Roxhill is undertaking a further consultation process. This consultation is focused on a very limited number of small-scale changes to the emerging proposals, and is to ensure local awareness of these changes which were made since the recently concluded Stage 2 consultation process.

The changes since the proposals were last consulted upon are:

Cross Section - I - I': Blisworth Road (Roade) Ch 100 Scale: H 1:100,V 1:100. Datum: 113.000

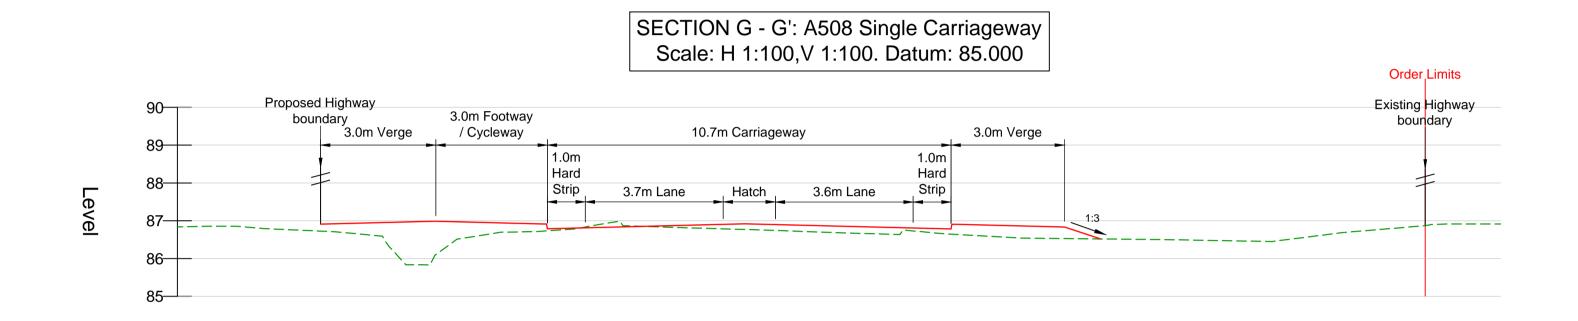
| Location | You said that | So we will |
|---|--|--|
| Knock Lane / Blisworth Road (Roade) | The road is relatively narrow and you are concerned about additional traffic. | Widen the road around the bend between the two long straight sections of road. This will enable vehicles to pass more comfortably than present at this point where the visibility is reduced due to the bend. This work will take place within the existing highway and does not require additional land outside the highway. |

SECTION S - S': A508 - Rookery Lane / Ashton Road Junction Improvement Scale: H 1:100,V 1:100. Datum: 92.500m

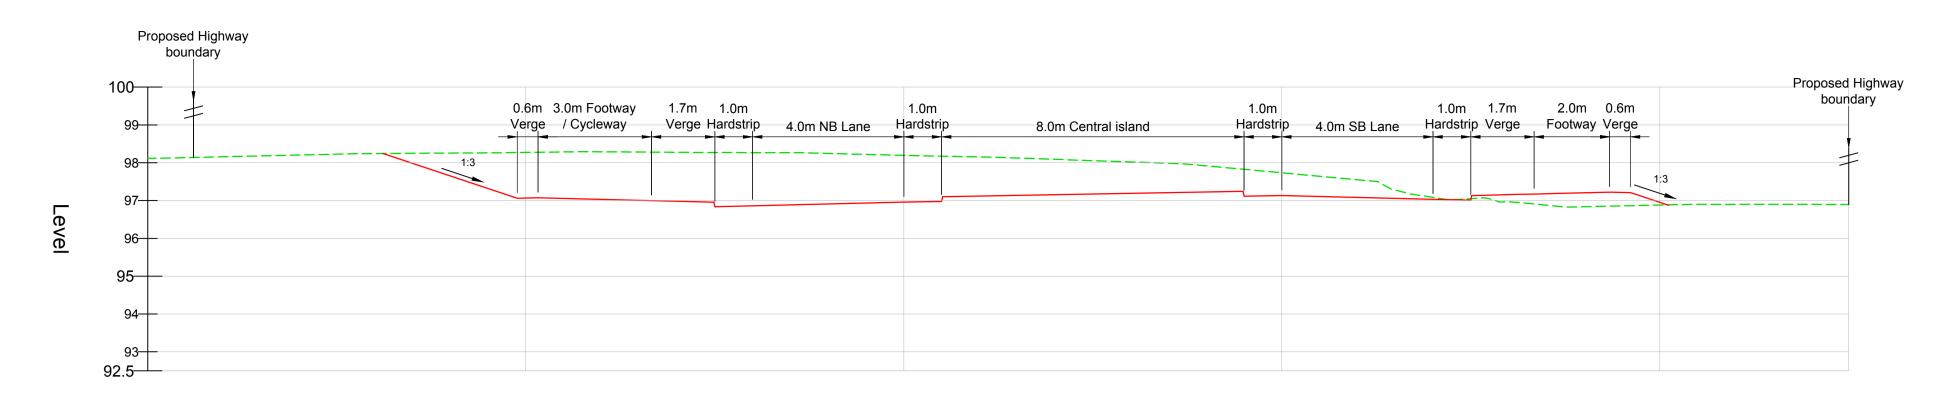
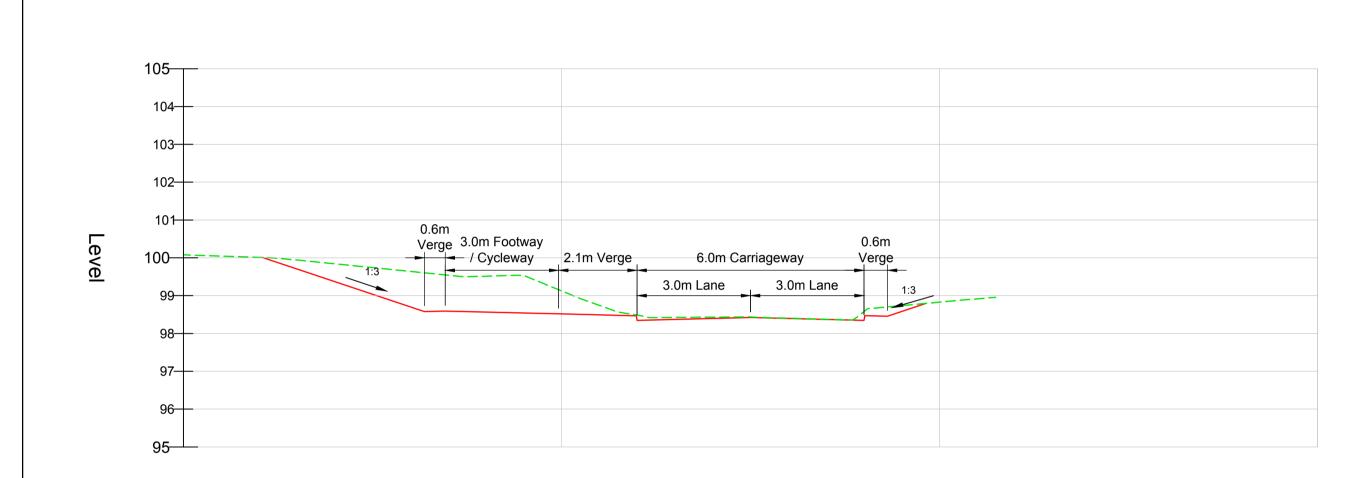
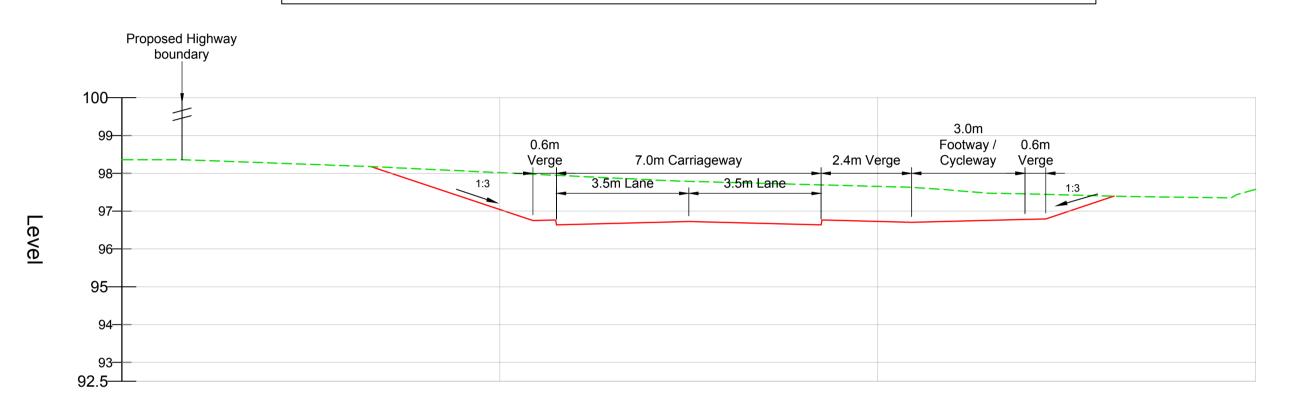
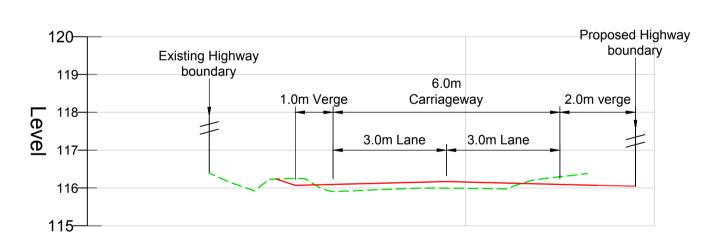
| Location | You said that | So we will |
|---|--|--|
| A508 Rookery Lane / Ashton Road junction (junction for Stoke Bruerne and Ashton) | Although improvements are welcome in principle, the junction proposal is wrong as it would make it more difficult to turn right out of the minor roads onto the A508 or to go straight on. | Change the junction proposal to provide, a large central area (known as 'single lane dualling'). This will enable drivers turning right from the minor roads, or going straight on, to make the turn in two moves i.e. crossing during a gap in traffic from the right and then turning or crossing during a gap in traffic from the left. |
| | There are no pedestrian or cyclist facilities proposed – how can we cross if there is more traffic? | Provide pedestrian and cycle crossing points over the A508, making use of the large central island. We will also provide a footway on the east side of the A508 along the frontage of the properties. |
